Tel: 01903 737756
Email: planning@arun.gov.uk
www.arun.gov.uk/planning
Please ask for: Jonny Cooper
Email: jonny.cooper@arun.gov.uk
Telephone: 01903 737532
Our Ref: BR/183/25/PDH
Your Ref:
Date: 20th October 2025

Prior Notification for a Permitted Development (Householder)

Development: Notification under extended permitted development rights for a single storey side & rear extension measuring 4.85m from beyond the rear wall of the original dwelling house, with a maximum height of 2.85m and eaves height of 2.85m.
Location: 47 Highfield Road Bognor Regis PO22 8PD

EXISTING REAR ELEVATION : West

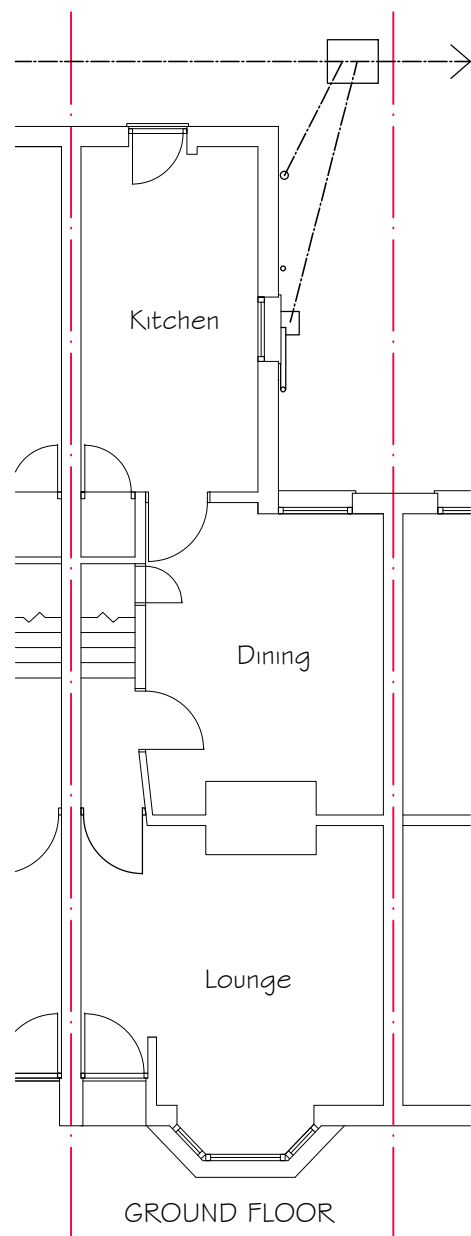
You are not able to change the existing fenestrations on the rear elevation; only the single storey rear extension can be considered under schedule 2, part 1, class a. Please amend your plans to remove the new double doors or confirm you would like the application withdrawn.
